**British Horse Society Bedfordshire (BHS Beds) comments on the Applicant's responses (REP2-044) to its Written Representation (REP1-099)**

This document uses the Applicant's references in Table 10 of its response document.

Pertenhall BW 26 and Bolnhurst & Keysoe BW 37 (APP-121 Masterplan sheets d and c, APP-010 Streetworks plan sheets 1, 2 and 3, APP-160 Outline PROW mgmt plan and APP-070 Visual Receptors Figure 5-4a)

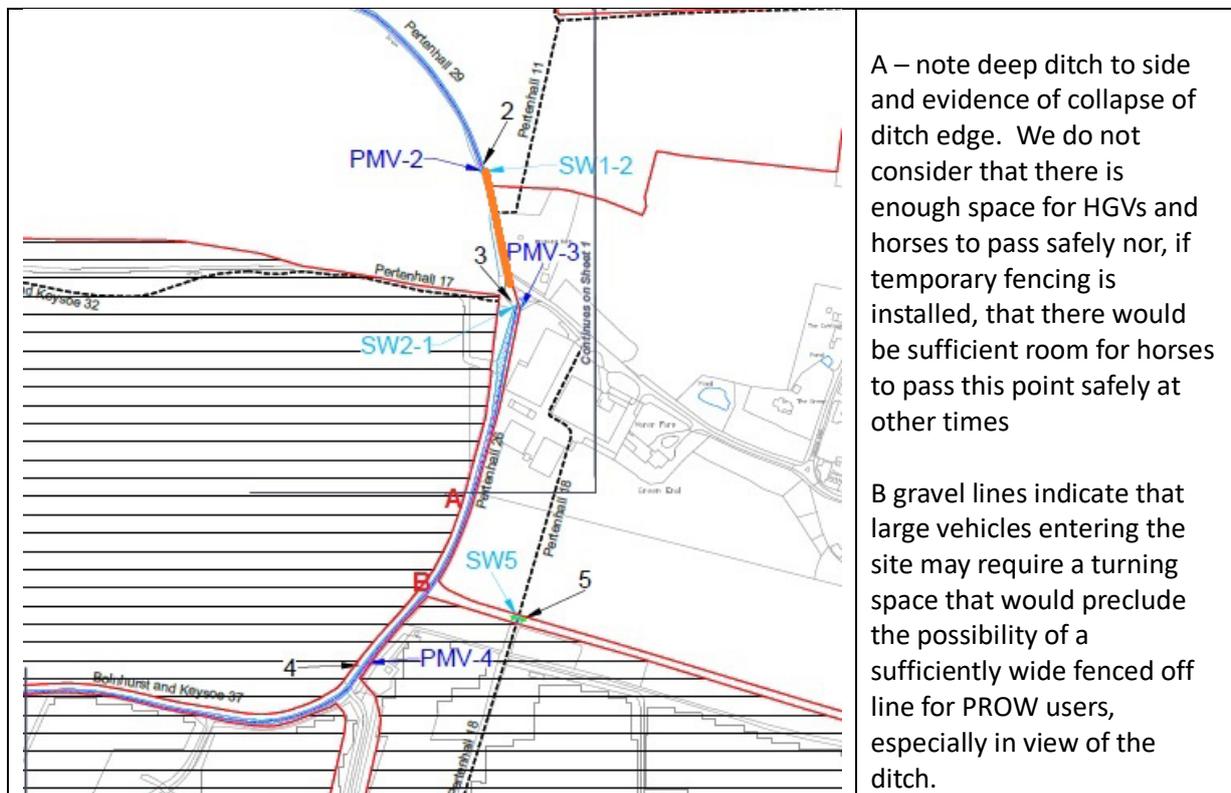
**BHSB-WR-02** - the Applicant acknowledges that the provision of a permissive route is a more limited public benefit than a permanent PROW. The route is already a permanent PROW, being a footpath, so the impact of agreeing to an upgrade to bridleway status is not a major change for the Applicant or the landowner but would be of significant long term benefit to local riders.

The Society remains of the view that only dedication (or agreed creation) can provide an appropriate mitigation for the permanent adverse impact on views from other bridleways as a result of the development.

**BHSB-WR-03** – In our response (REP2-061) to the Applicant's responses to our RR-1253 (REP1-055 and REP1-056), we set out in some detail why we find the Applicant's proposals to address our safety concerns totally implausible and impractical.

- the proposed banksman will not be able to see all approaching horses,
- the suggestion that lorries stop or follow at a distance is unrealistic and could create further safety issues, and
- the idea that instructions to stop work can be communicated in time is implausible.

The Society remains of the view that the only safe option here is to provide an alternative diversion further away from the construction traffic and activity. This is within the gift of one of the landowners who is benefitting from this development. To continue with the current proposals is to close the bridleway to equestrian users during construction hours, without acknowledging that this is the case. And thus to deprive some local riders of access to off-road riding for some 18 months (possible two summers).

Alternatively, the Applicant could consider removing the panels from the section alongside the bridleway on the ridge at the western end of the development. This has already been suggested by Bolnhurst Keysoe Parish Council to address visibility issues (REP-128).

Access to and cabling from the other panels in Site A would be via the access roads within the northern array areas. This would remove the need for any construction traffic to use the bridleway to the west of the Manor Farm, save for about 100m to reach the track to the panels within Site A that are next to the B660. Array installation and cable laying on or adjacent to this BW could be eliminated. There would be some installation noise alongside BW44 near Middle Lodge, which should be manageable for the presumably small period of time involved, as alternative equestrian routes would be available. The traffic associated with the green infrastructure installation could also be diverted away from the BWs for the most part and presumably the work involved would not be unduly noisy nor require the vibration inducing pile driving associated with panel installation.
